NORTH LINCS S51 ADVICE – EST INPUT – 12 April 2022

Environmental Statement (ES) (Volume 6)

Raised Walkway & Living Wall - Ground Floor Plan

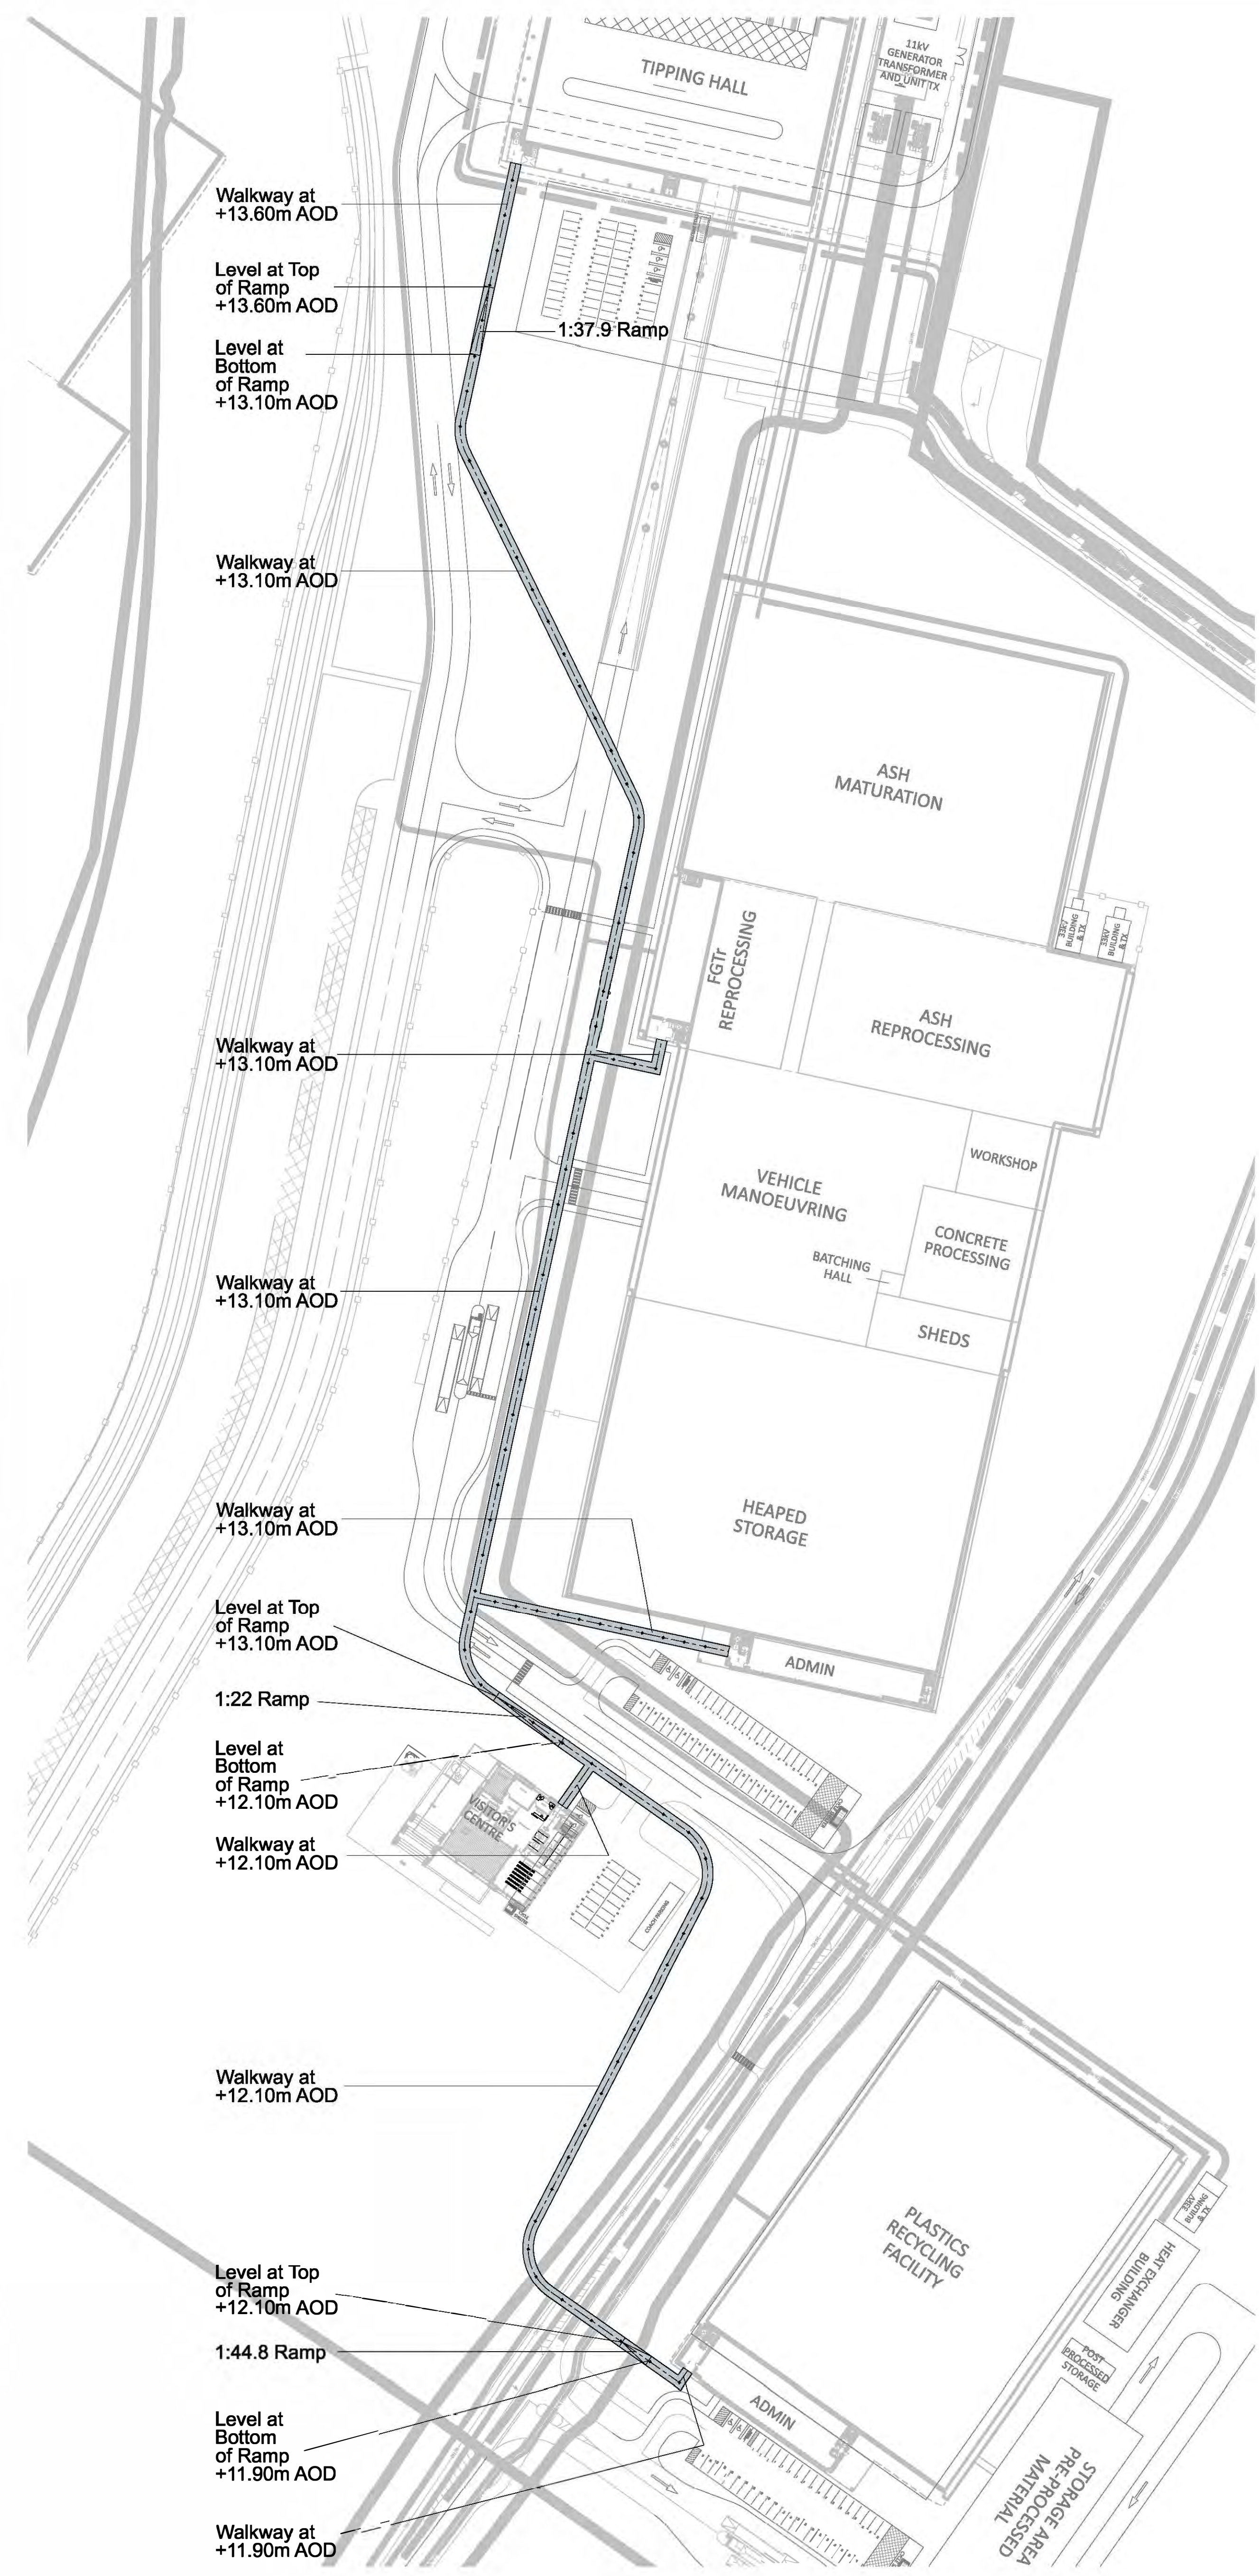
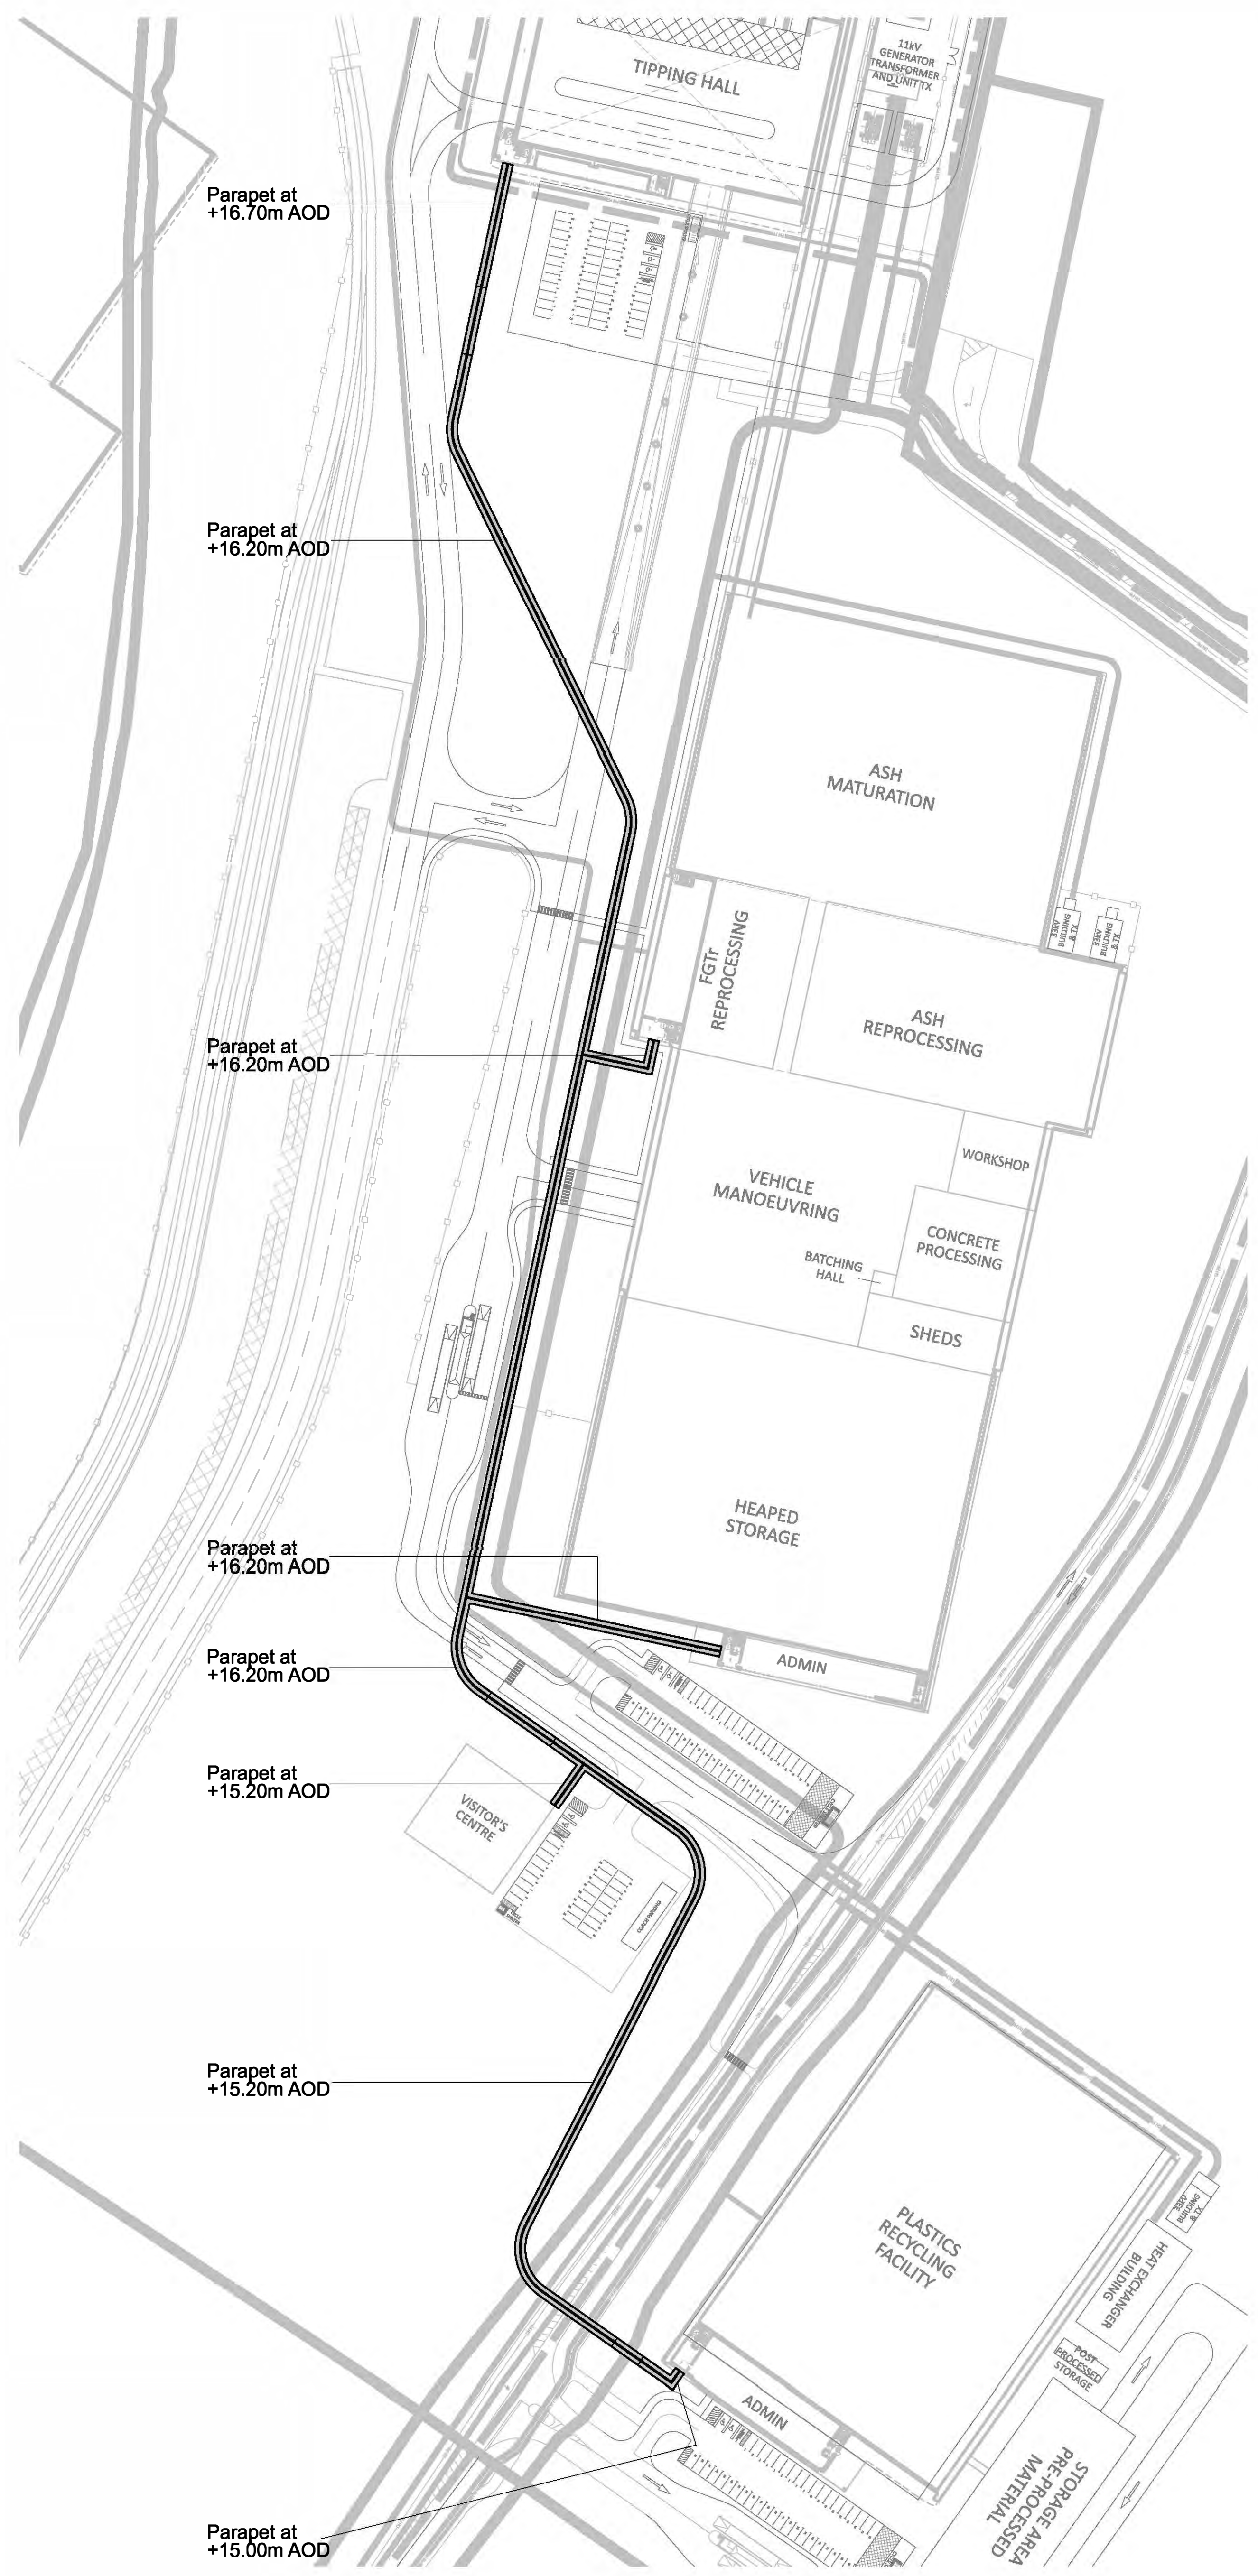
ES Chapter 3 Project Description and Alternatives paragraph 3.2.37 describes a covered elevated walkway between various Energy Park buildings. The potential impacts of the walkway have not been explicitly assessed within the ES and, of particular note, it is not referenced within ES Chapter 11 Landscape and Visual Impact. The Applicant is advised

to perform an audit of the ES to ensure that any likely significant effects of this element of the Proposed Development are clearly identified and assessed.

CRS EPSG 27700
CRS Name British National Grid
Scale 110,000
Drawing No NLGEP-ERM-XX-XX-DR-Z-0013
ArcMap File EC_ES_STAT_NONSTAT_DesignatedSites_15kmBuffer_P0

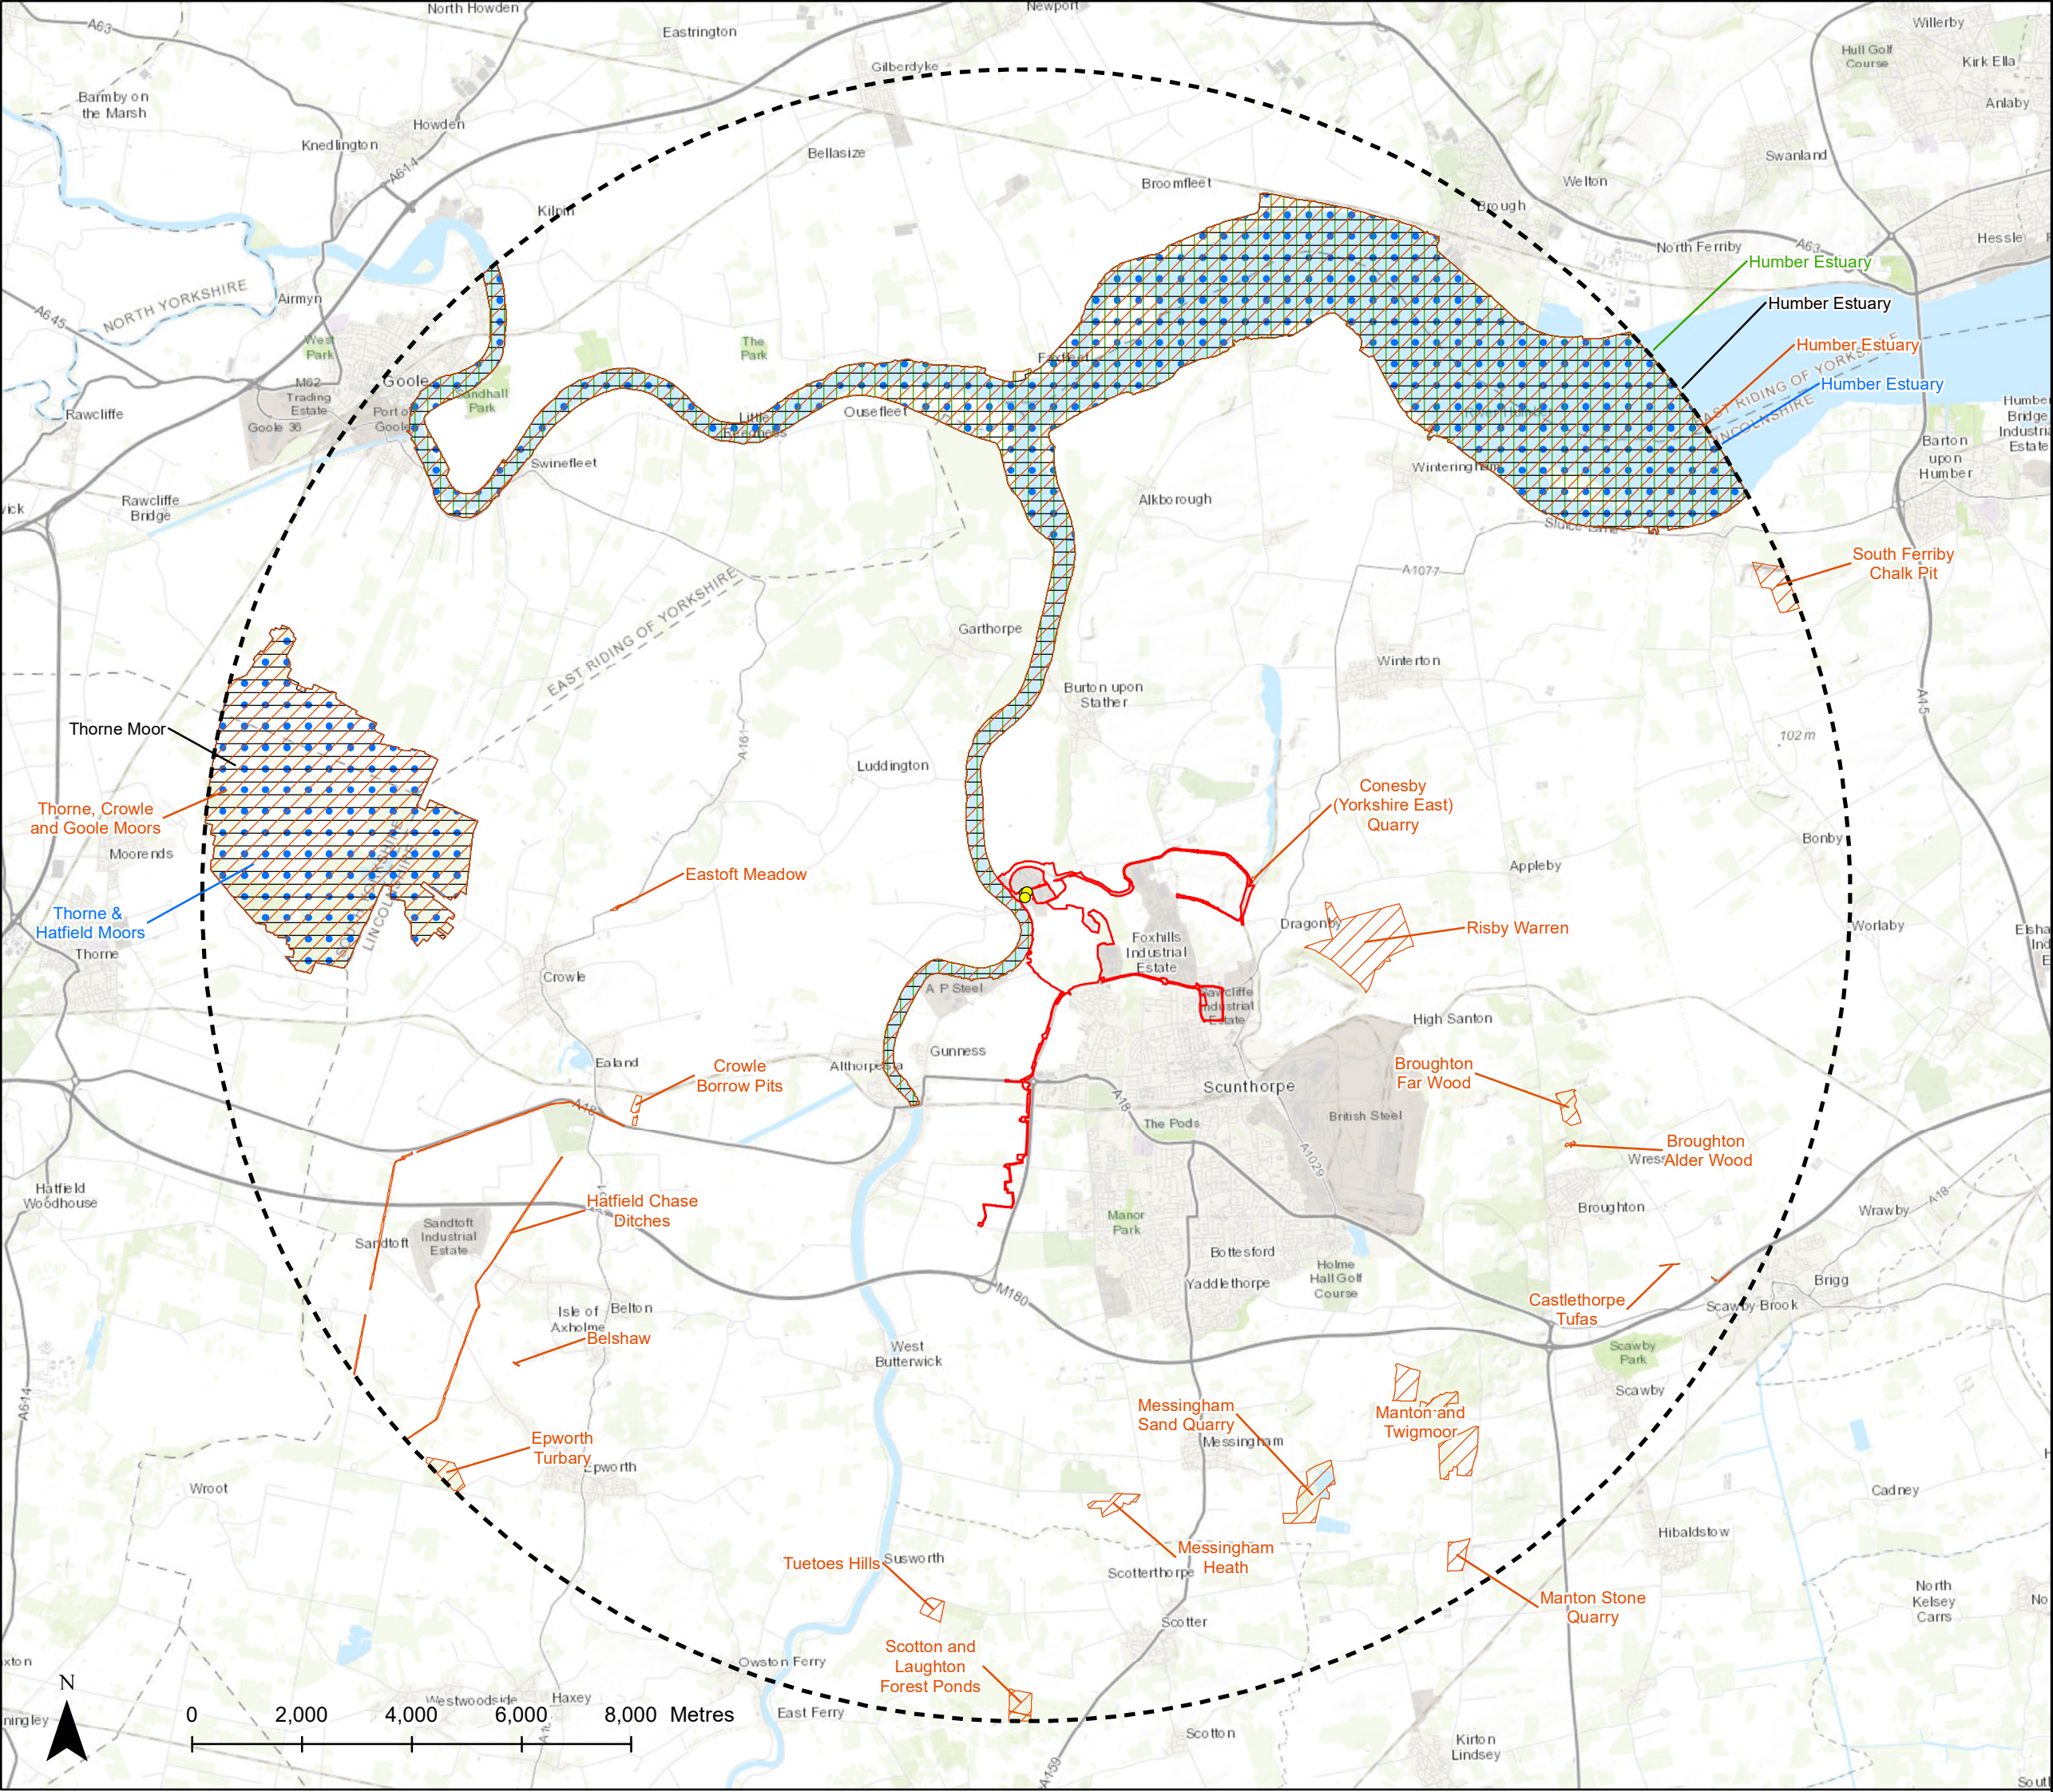
Hatfield Moor Special Area of Conservation (SAC) is not shown on the plan illustrating European sites and SSSIs (Drawing Number NLGEP-ERM-XX-XX-DR-Z-0013). The Report to Inform HRA states that this European site is located just outside the 15km study area and therefore was screened out of the assessment. However, ES Chapter 10 Ecology and Nature Conservation describes the site as being 12.4km from the Proposed Development. The Applicant is advised to clarify these discrepancies and to provide an assessment of any likely significant effects to the SAC if it is located within the 15km study area.
